Response to Planning application from Hertfordshire County Council (T and CP GDP Order 2015)

District ref: 6/2017/0618/FULL

58 Plough Hill

Erection of a detached dwellinghouse following the demolition of existing

Proposed Ground floor Plan 1:50

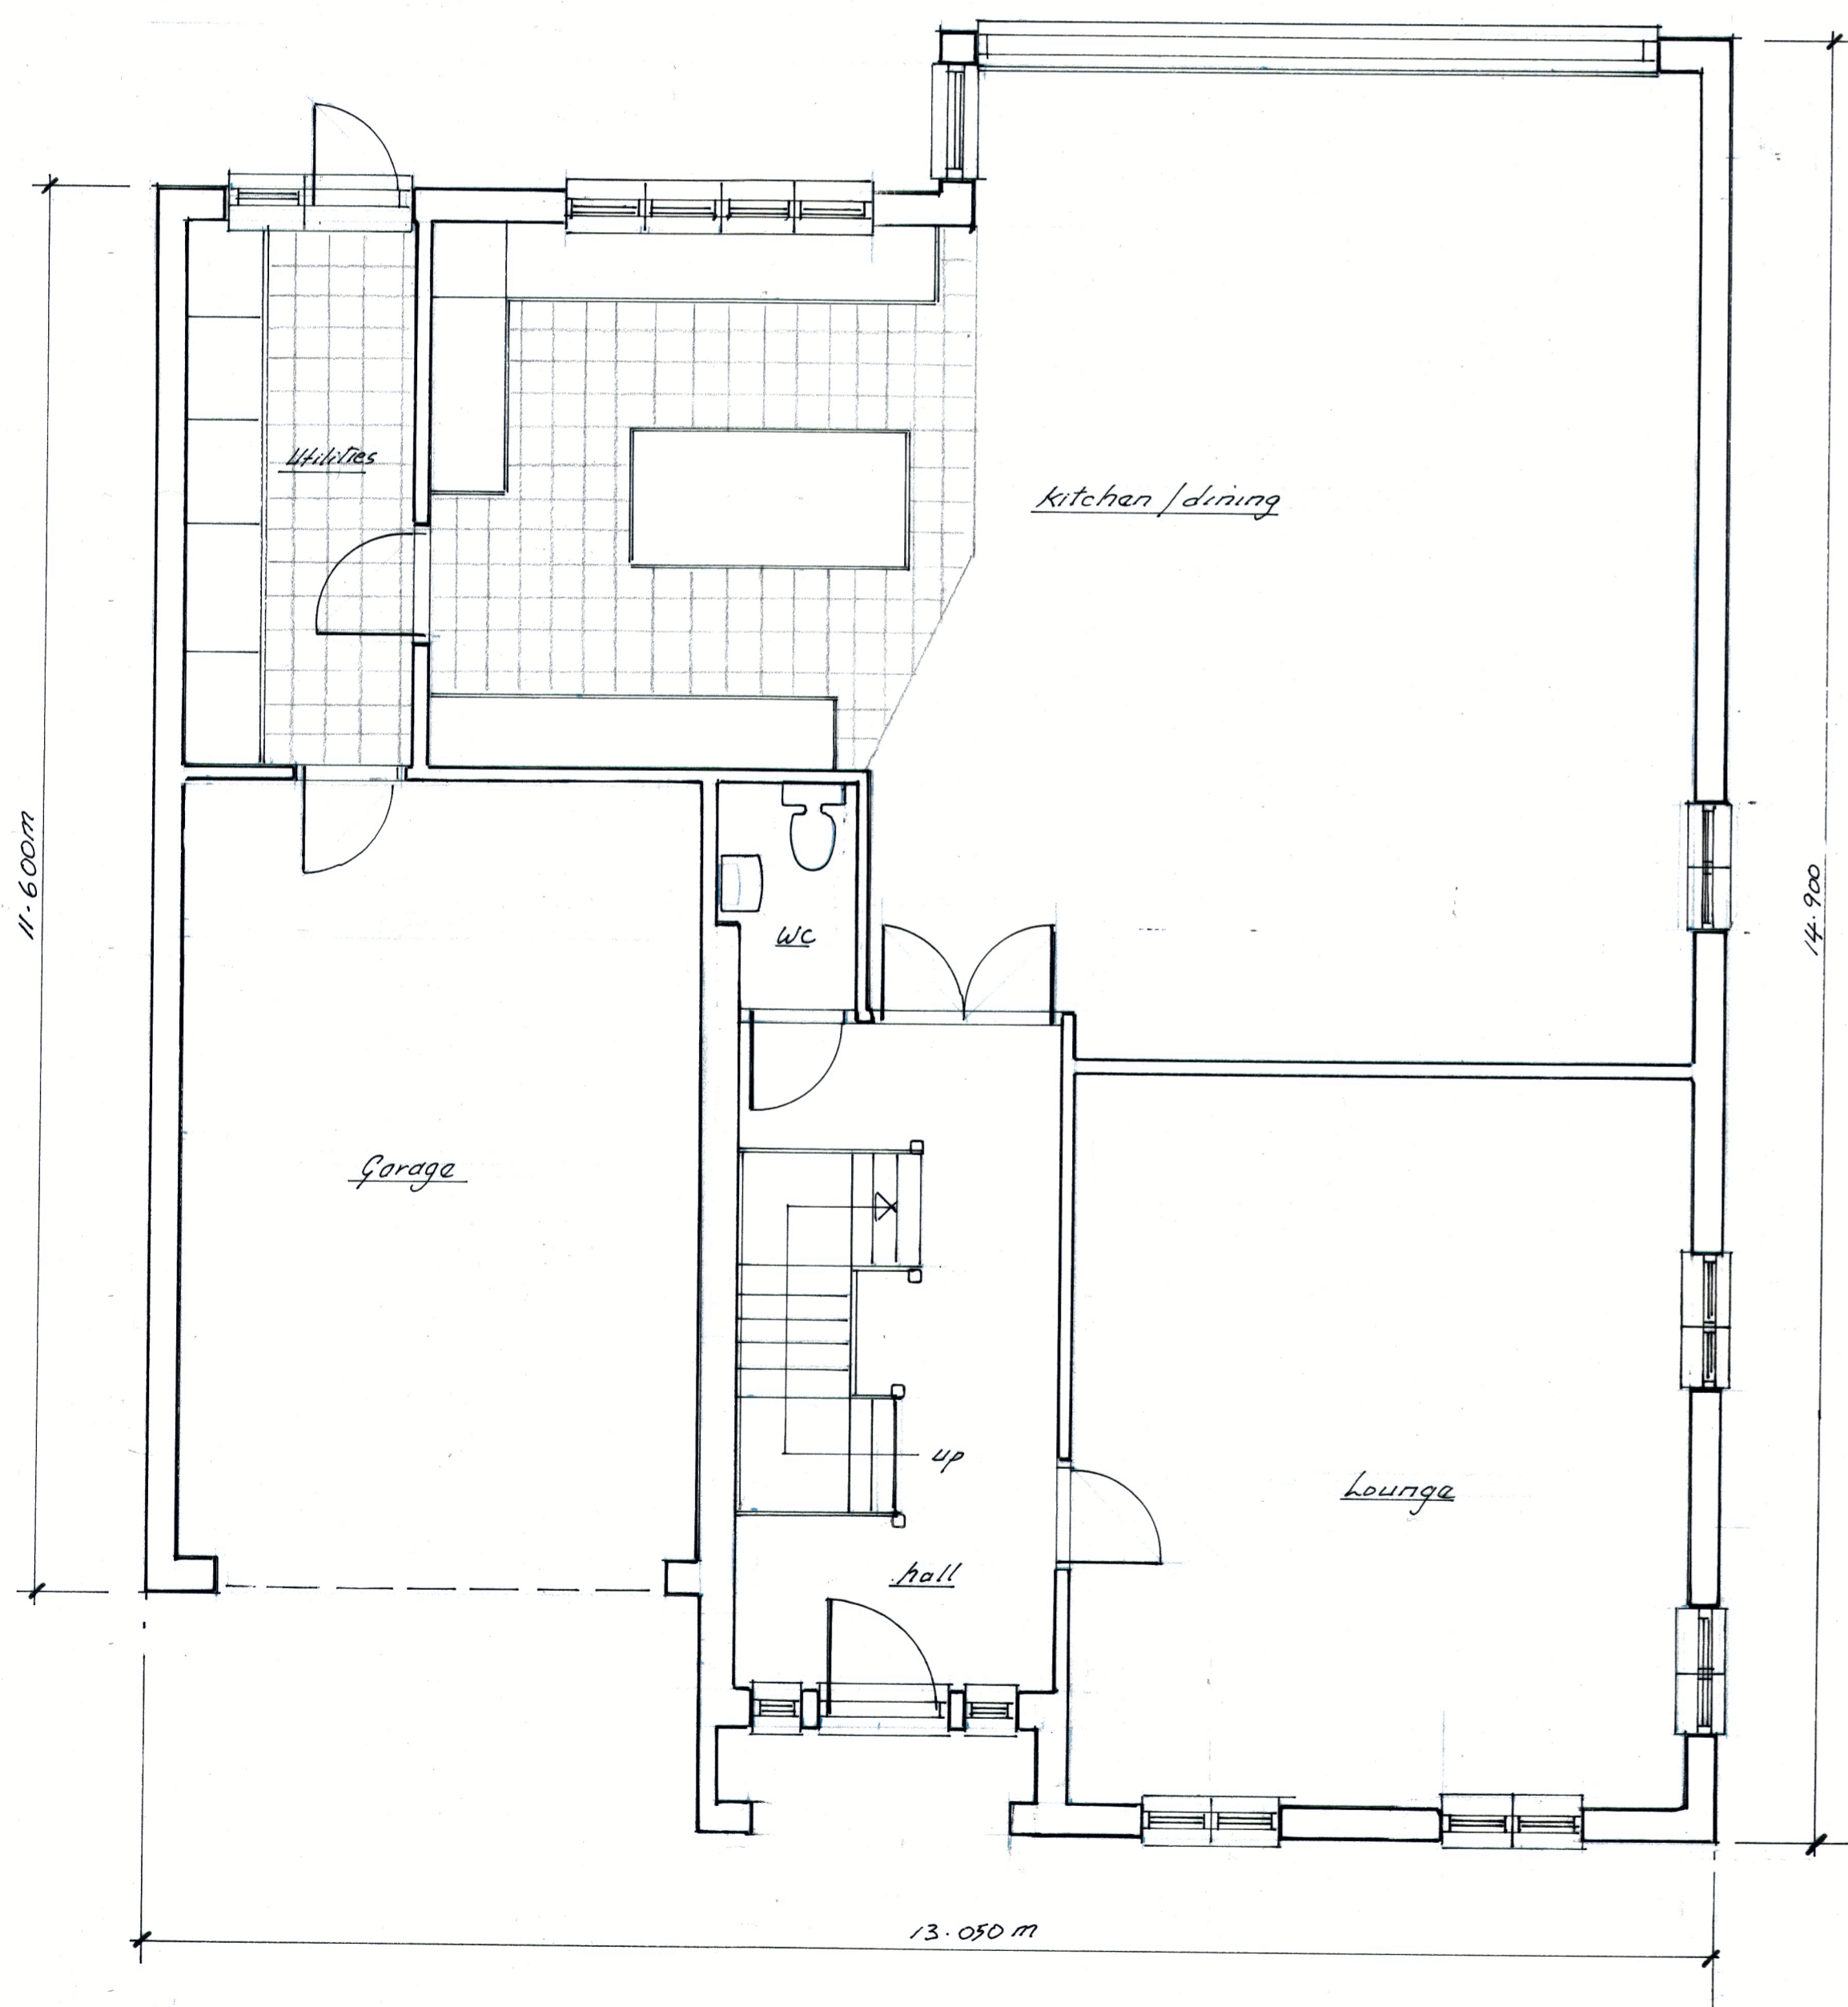
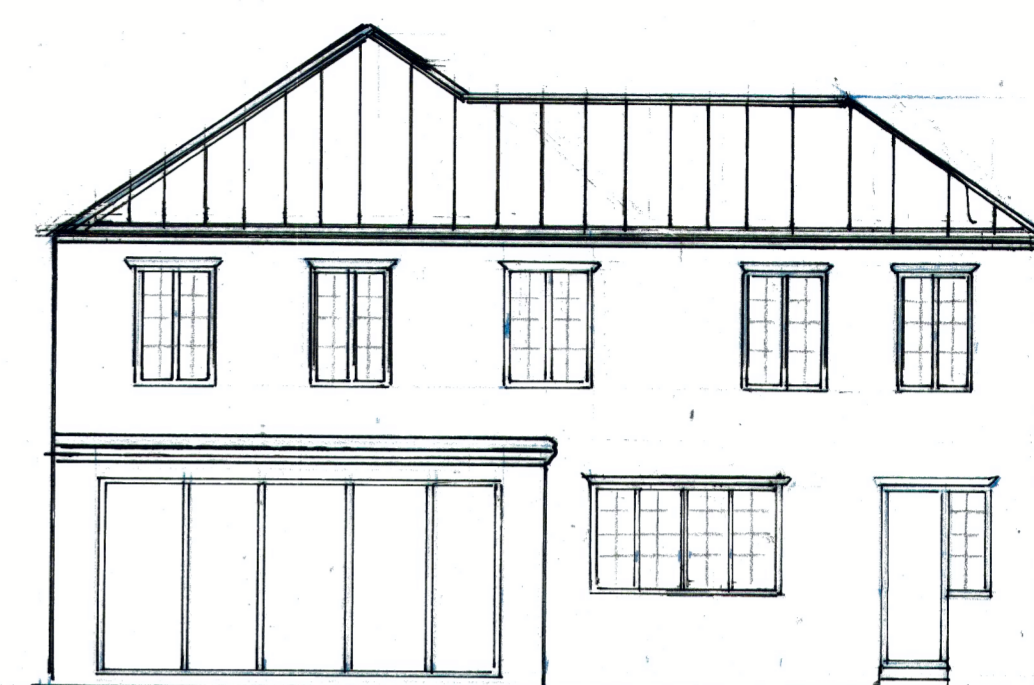
The amended proposal indicates a new frontage wall within the public highway. Our records show that the grass verge in front of the existing wall has highway rights and is maintained at public expense. This strip of land most likely also provides access to service facilities. It is also noted that the highway tree has been removed, and further information regarding its removal is being sought.

It is on the grounds of a structure within the highway that the application should be refused.
